Consultation Response from: KC Environmental Health (Pollution & Noise Control)
2021/92106 - Phase 1, Former North Bierley Waste Water Treatment Works, Oakenshaw, BD12 7ET
Discharge of conditions 8 (construction environment management plan) and 26 (surface water disposal) of previous outline permission 2016/92298 for redevelopment of former waste water treatment works following demolition of existing structures to provide employment uses (use classes B1(c), B2 and B8)
Date Responded:
1st July 2021

Condition 8 - Construction Environment Management Plan

To discharge Condition 8, a Construction Environment Management Plan by GMI Construction Group dated 4th May 2021 (ref: Rev 1) has been received. Our comments relate to those within the remit of Environmental Health, these include working hours, noise and vibration from construction activities and vehicle movements, dust from construction activities and vehicle movements and artificial lighting used in connection with all construction-related activities and site security. There are other aspects of the statement that are outside the remit of Environmental Health and may be subject to comments from other consultees.

Figure 1 – Site Location and Site Plan

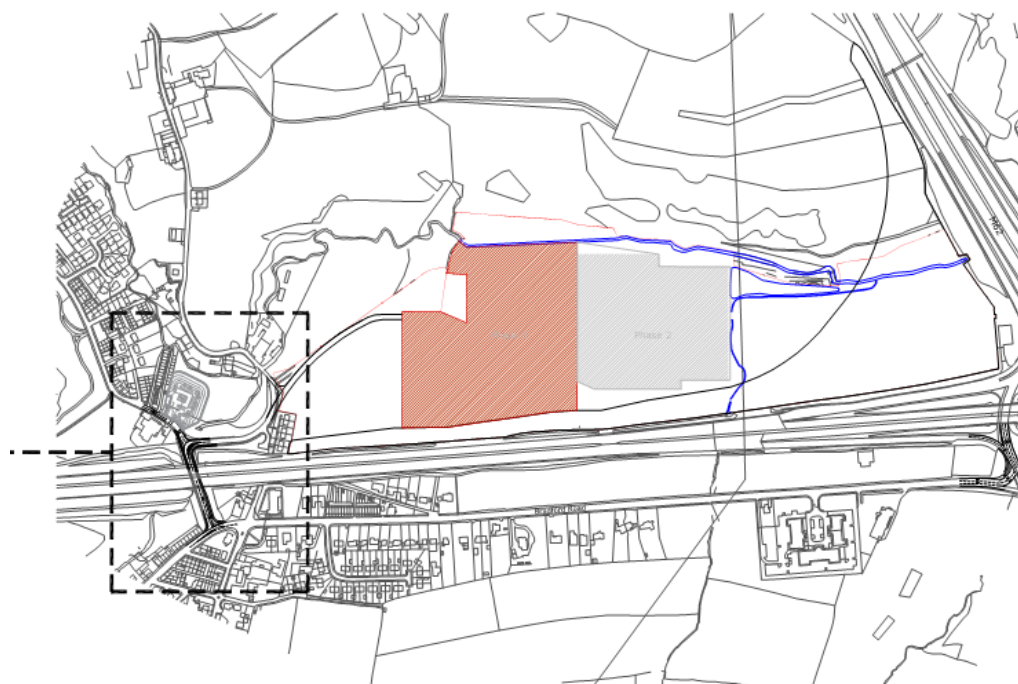
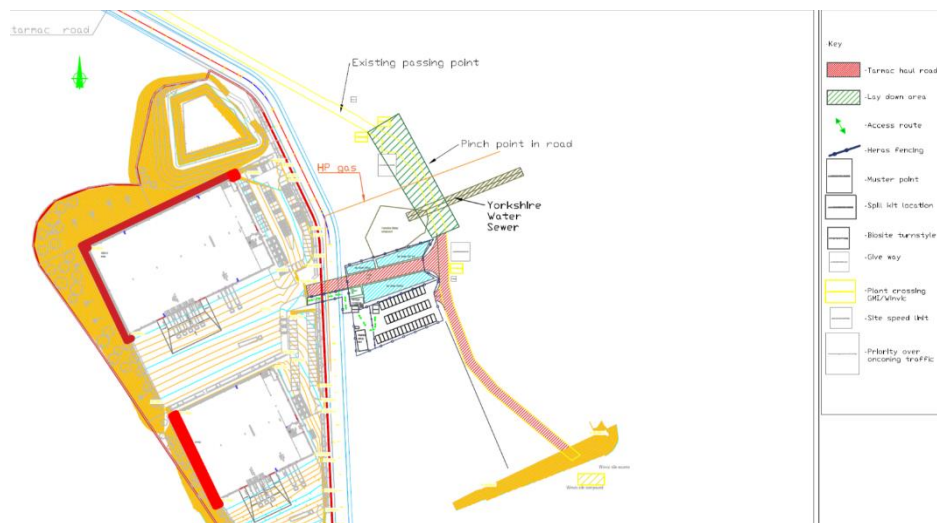
6. No site plan has been provided showing the location of any control measures or the location of welfare facilities, compounds etc. These should be included in the construction management plan.
